Our Ref: STH08/01370
Contact: Andrea Boes 4221 2771
Your Ref: MP06_0335 MOD 2
MP06_0209 MOD 4

**WOLLONGONG CITY COUNCIL – MAJOR PROJECT – WEST KEIRA DEVELOPMENT &
WOLLONGONG CENTRAL REDEVELOPMENT, WOLLONGONG – MP06_0335 MOD 2 &
MP06_0209 MOD 4**

11 MAY 2012

DRAWING TITLE:
OVERALL FLOOR PLANS
LEVEL 1 LOWER GROUND FLOOR
RETAIL

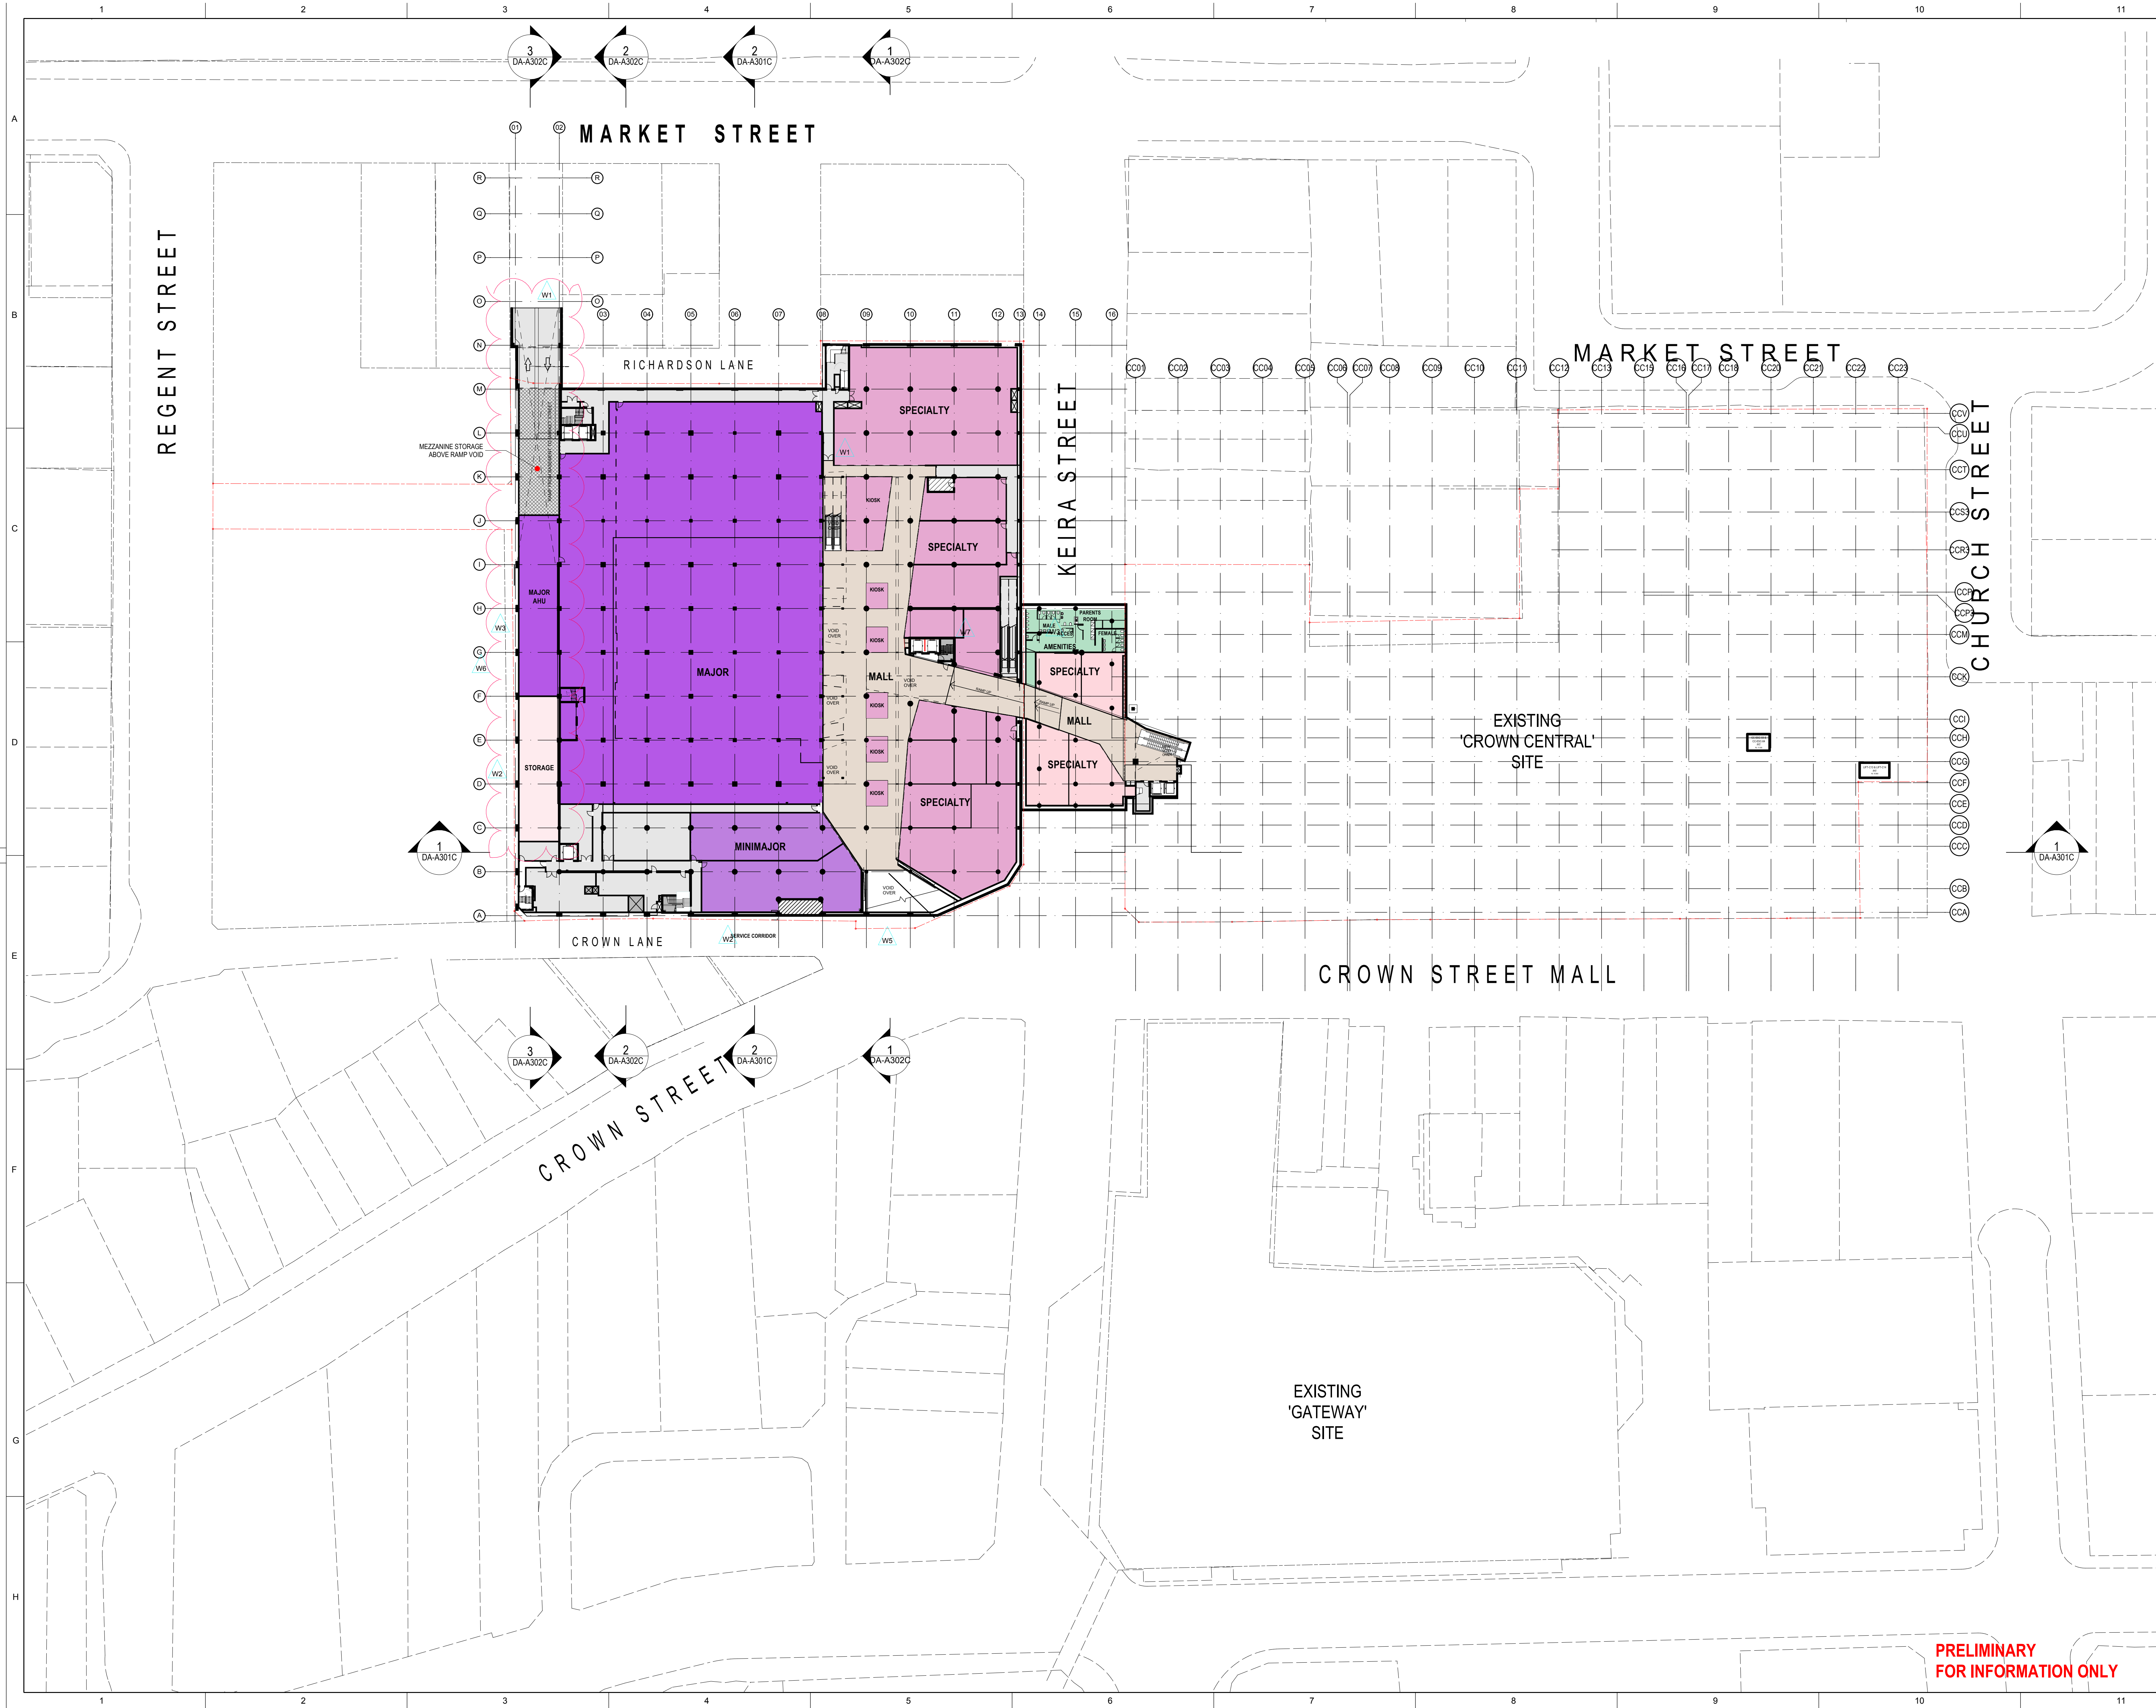
- RMS notes that the proposal to relocate the entrance to the public car park from Richardson Lane to 71 Market Street. In this way, vehicles will be turning further west away from the intersection of Market Street and Keira Street. RMS supports this.
- RMS notes that relocation of the car park access separates the access points to the development for service vehicle traffic and general public car park traffic. RMS supports this.
- With the information provided, RMS is unable to comment on the removal of the requirement for a right turn bay on Market Street. Parking should be restricted on the northern side of Market Street to allow vehicles travelling through eastbound to pass a stationary vehicle waiting to turn right into the development. However, this is considered a matter for Council's consideration.

Given the above, RMS does not object to the proposal subject to the design meeting Council's satisfaction. If you have any questions please contact Andrea Boes on 4221 2771.
